From: Stacey Mcalwane
Sent: 25 July 2019 16:31
To: Paul Savage <; Lizzi Wilson < Sam Jeavons <
Subject: [EXTERNAL] FW: EXTERNAL -RE: 18/01309/REM Crest Nicholson, Blossom Fields play area 15410E

From: Judith Ward <Judith.Ward@cherwellandsouthnorthants.gov.uk>
Sent: 22 July 2019 11:42
To: Stacey Mcalwane <
Subject: RE: EXTERNAL -RE: 18/01309/REM Crest Nicholson, Blossom Fields play area 15410E

From: Judith Ward <Judith.Ward@cherwellandsouthnorthants.gov.uk>
Sent: 17 June 2019 08:24
To: Stacey Mcalwane
Subject: RE: EXTERNAL -RE: 18/01309/REM Crest Nicholson, Blossom Fields play area 15410D

Revision			
A	Site redesigned due to new budget	AW	17.10.18
B	Site redesigned to client's comments	PL	21.11.18
C	Site redesigned to client's comments	AW	26.04.19
D	Site redesigned with new kit	AG	31.05.19
E	Surfacing amendment around single gate	AM	01.07.19

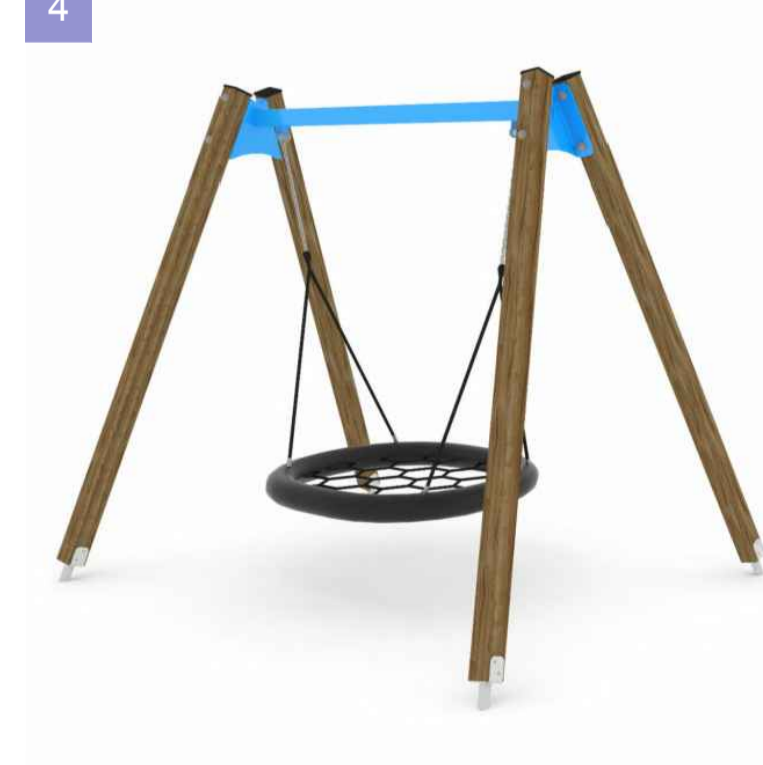
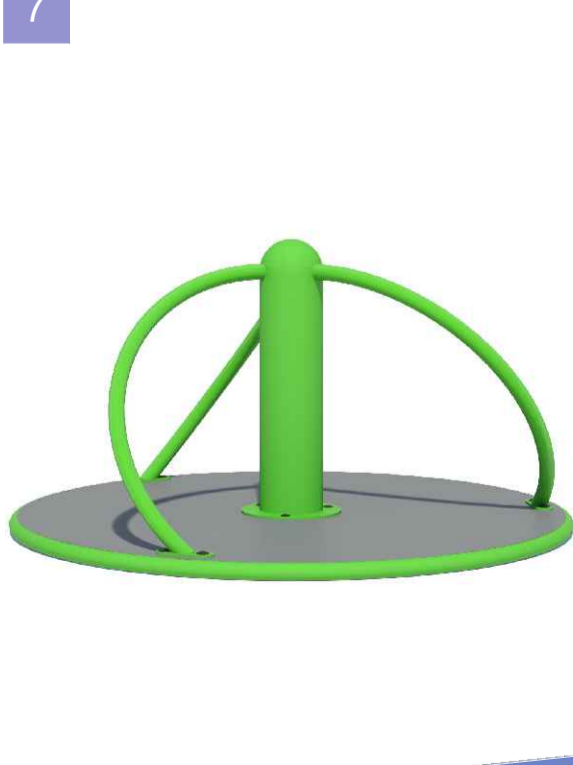
The sign will need to be procured by the Parish Council when the site is handed to them and we ask that the developer gives them a sum of money to do this. Please show a sign with a note to say the developer will pay a sum for it.

I am left wondering why one of the bins has been moved to outside the fenced area? It needs to be inside and on surfacing not grass which just gets worn.

I also think the grass mat near the single leaf gate would be better extended to avoid a narrow area of grass between the planting and play equipment 1.

The bin has been moved inside the play area onto the mulch area which has been extended to cater for this and likewise the grass matting has been slightly extended so avoid any small gaps of wear.
